# BCA 2022 AMENDMENT 2 CAPABILITY REPORT FOR SSDA SUBMISSION

<b>CLIENT:</b>	TQM
<b>PROJECT NAME:</b>	LOTUS, HURSTVILLE MIXED USE DEVELOPMENT
<b>PROJECT ADDRESS:</b>	105 FOREST ROAD & 1A HILL ST, HURSTVILLE NSW 2220
<b>DATE:</b>	10 SEPTEMBER 2025
<b>PROJECT NO:</b>	250343

BASEMENT LEVEL 5

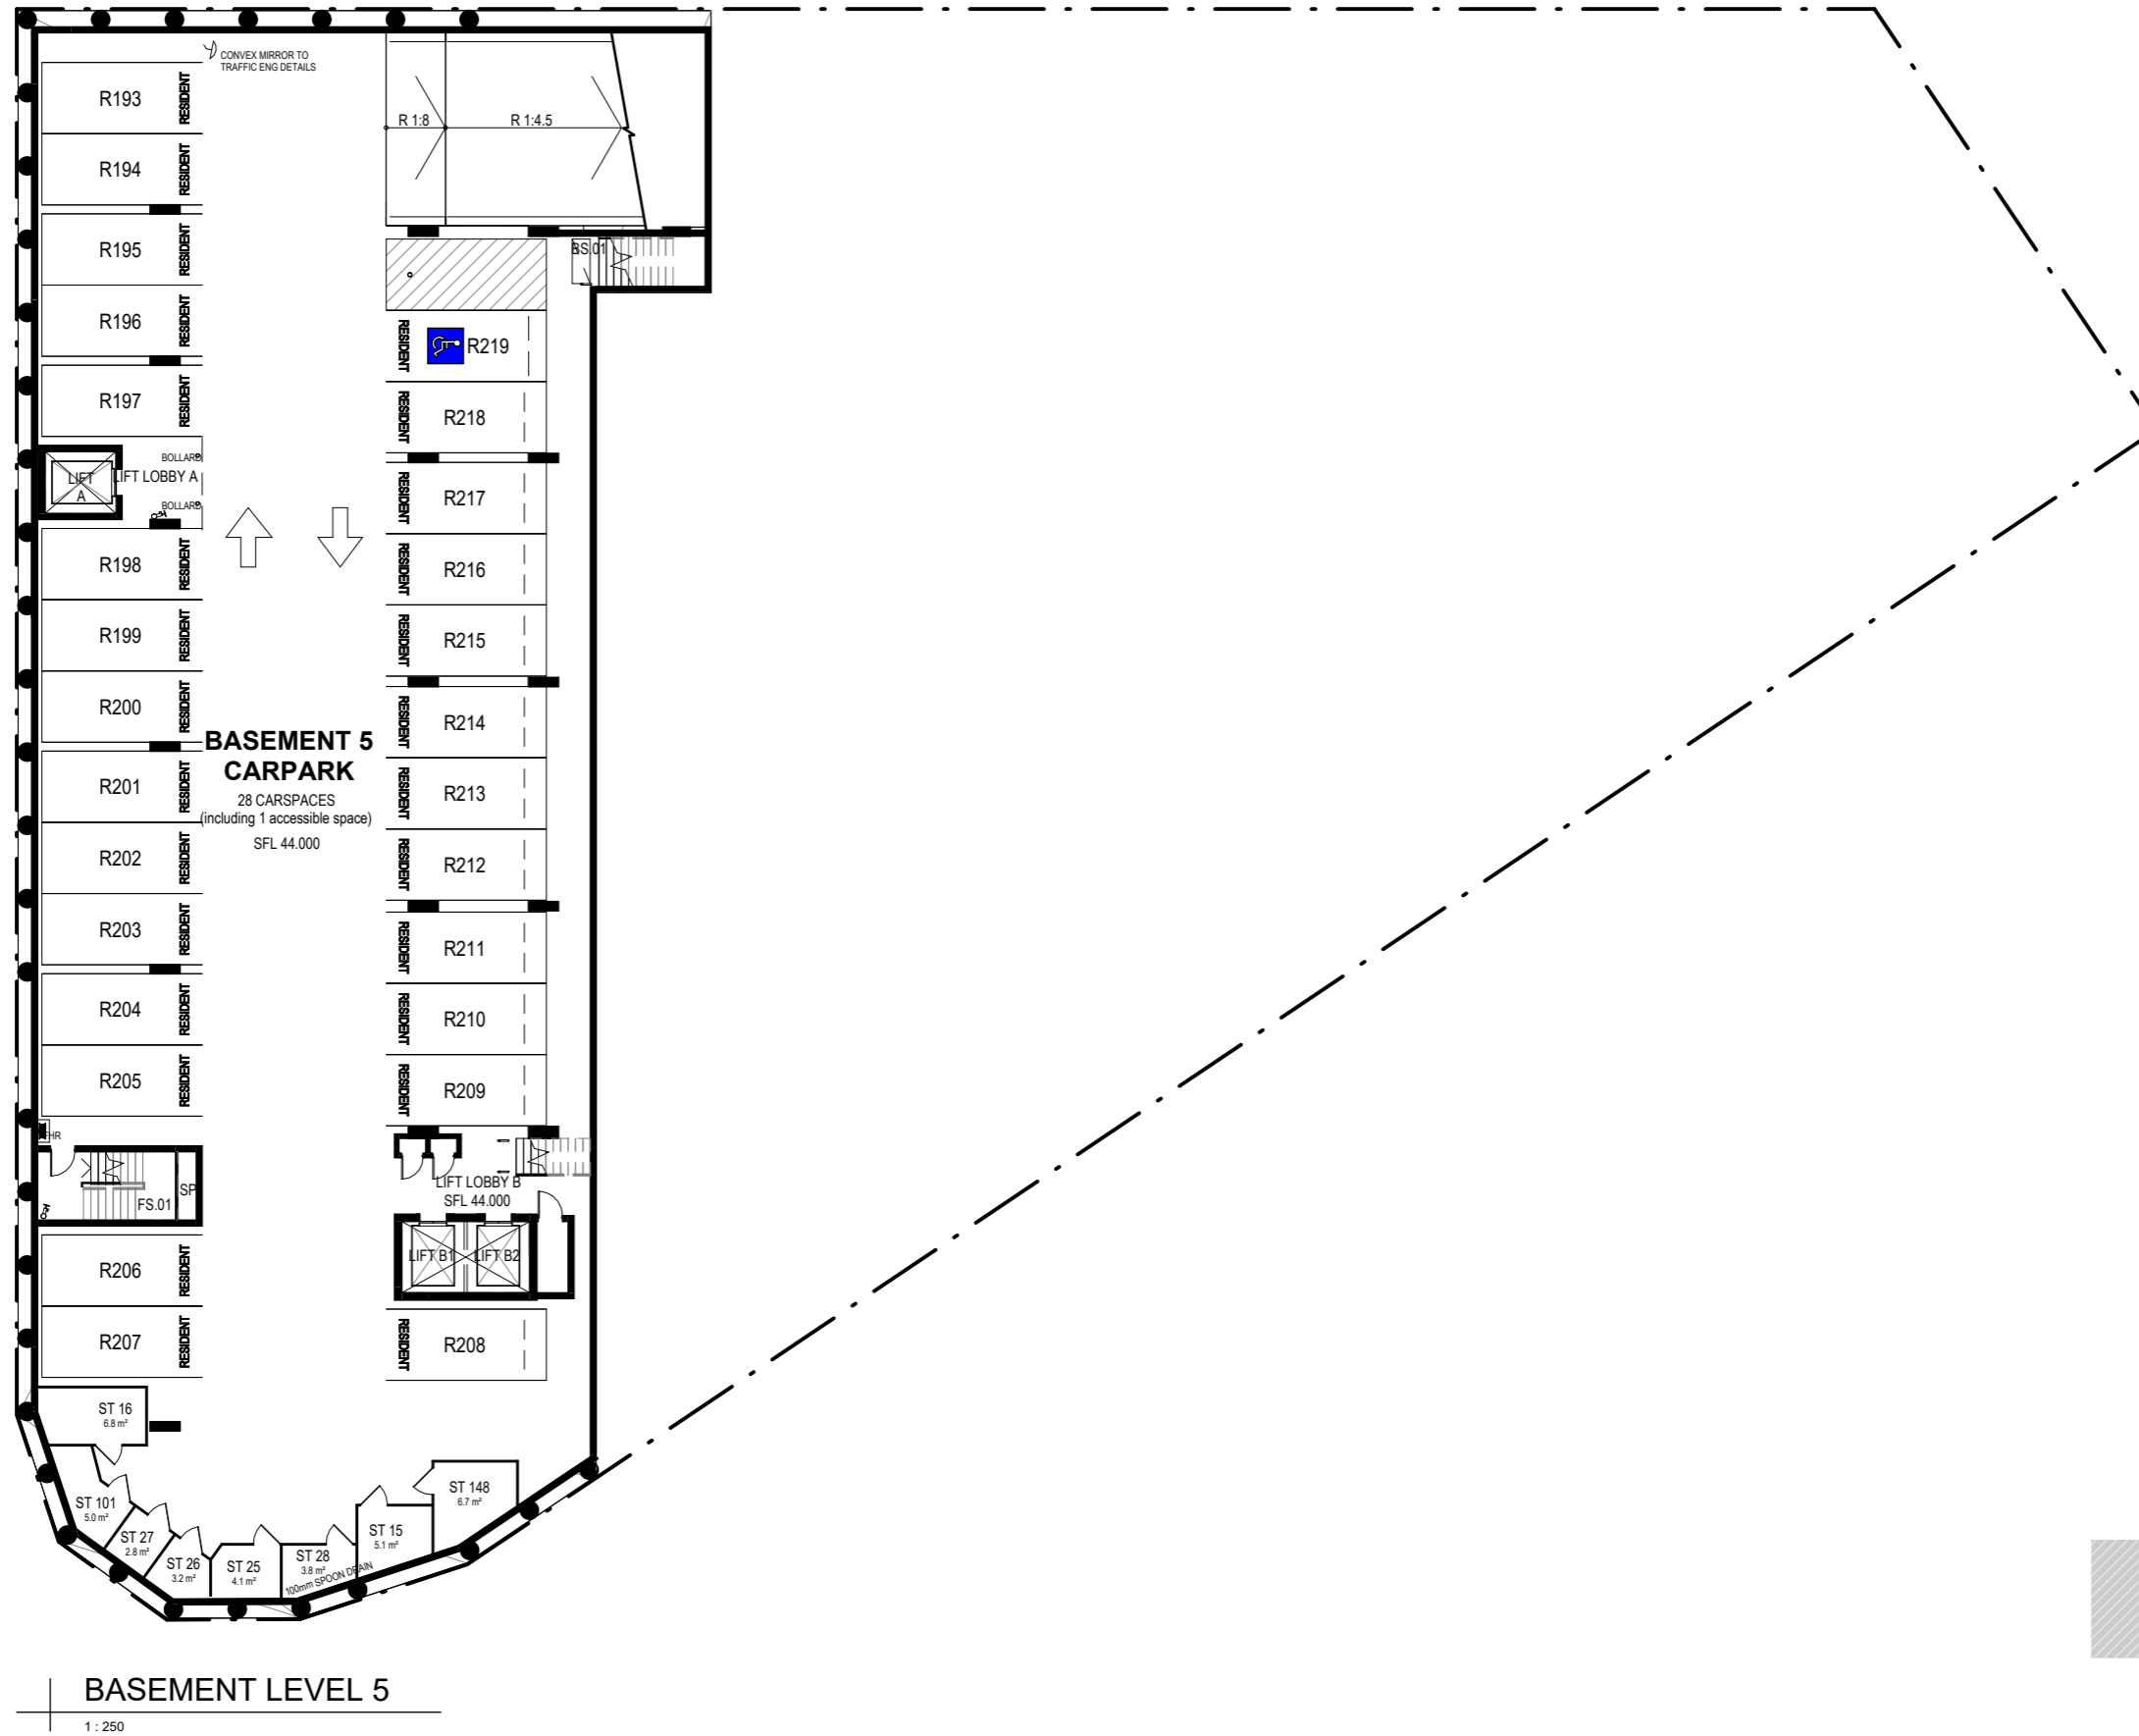
<p>5.</p>	<p>D2D5</p>	<p>The following extended travel distances have been identified:</p> <p><b>Basement Level 5:</b>          Extended travel distance is measured up to 49m in lieu of 40m to an exit.</p>  <p><b>Basement Level 4:</b>          a) Extended travel distance is measured up to 42m in lieu of 20m to a point of choice.</p>	<p>A performance solution by the Fire Safety Engineer will be required to address these non-compliances.</p>
-----------	-------------	---	--

BASEMENT 3 CARPARK
 64 CARSPACES
 (including 13 accessible space)
 SFL 49.000

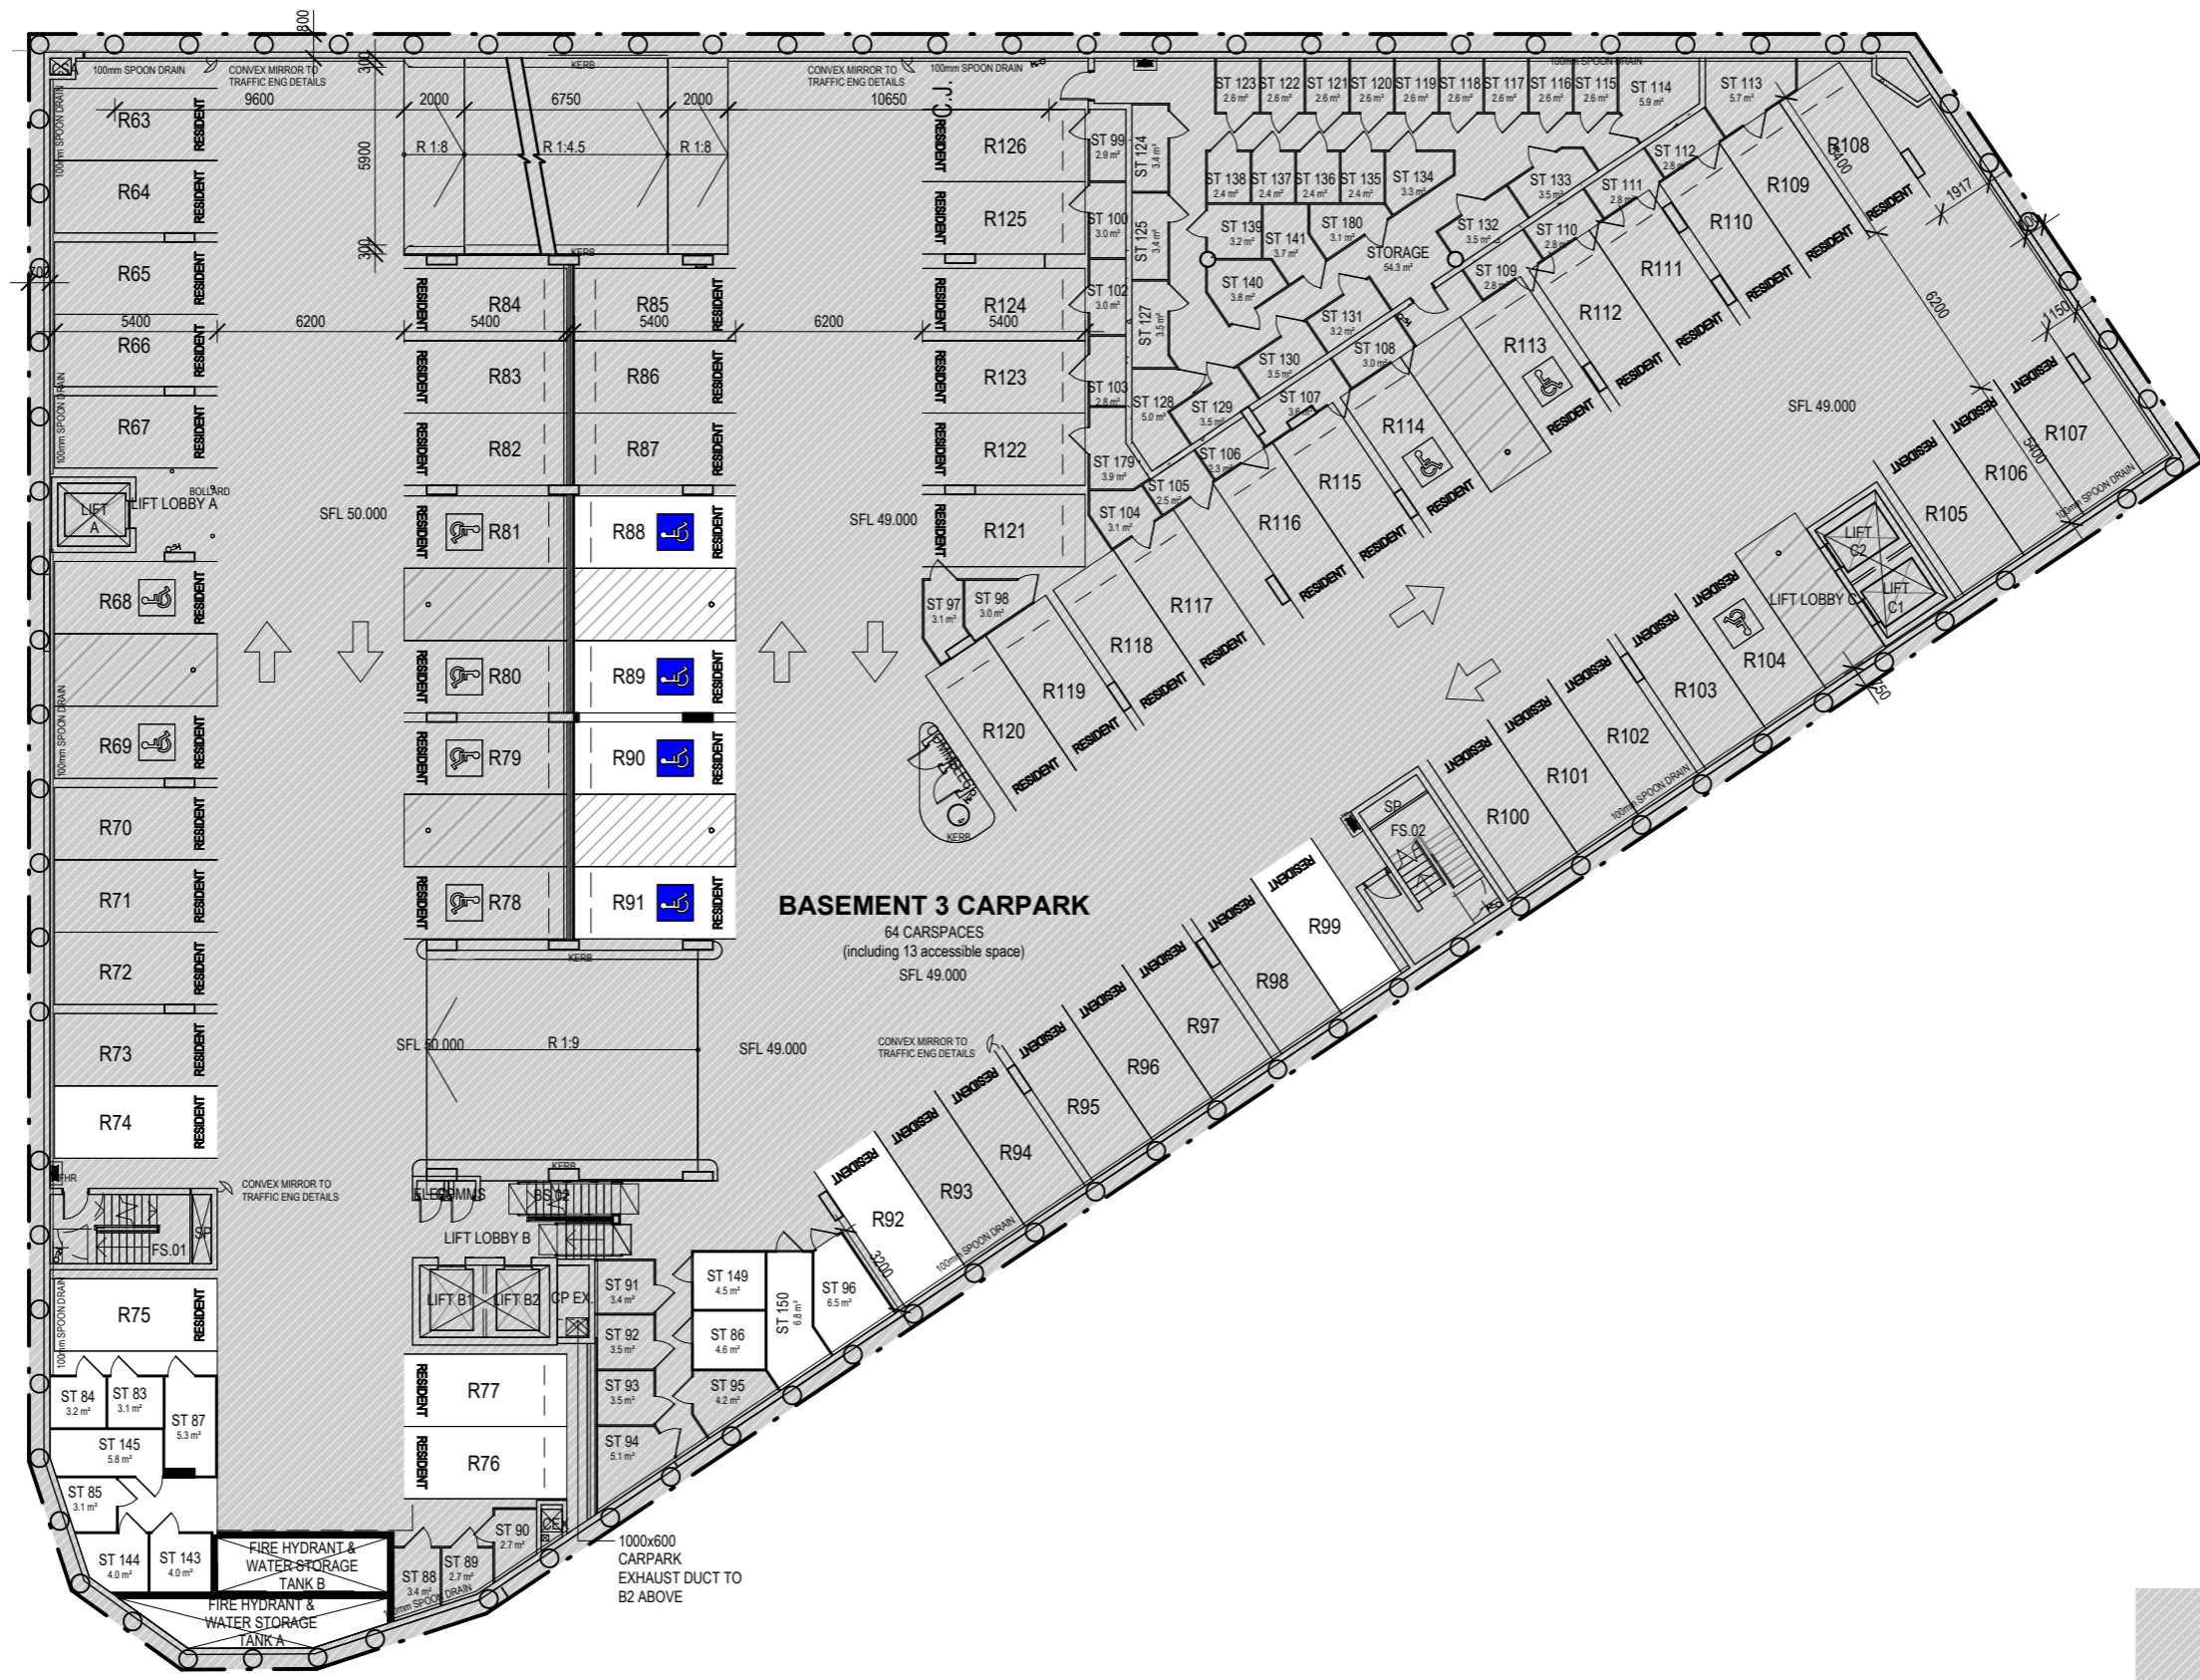
<p>7.</p>	<p>D2D8</p>	<p><b>Basement Level 4:</b> A 1000mm unobstructed width is required along the path of travel to an exit. 850mm width is identified on the plans.</p>  <p><b>Basement Level 3:</b> A 1000mm unobstructed width is required along the path of travel to an exit. 640mm and 750mm widths are identified on the plans.</p>  <p><b>Basement Level 2:</b> A 1000mm unobstructed width is required along the path of travel to an exit. 640mm and 750mm widths are identified on the plans.</p>	<p>Updated plans demonstrating compliance are to be provided or, alternatively, a performance solution by the Fire Safety Engineer will be required to address these non-compliances.</p>
-----------	-------------	---	---

Basement Level 3:

a) Extended travel distance is measured up to 42m in lieu of 20m to a point of choice.

b) Extended travel distance is measured up to 49m in lieu of 40m to an exit.
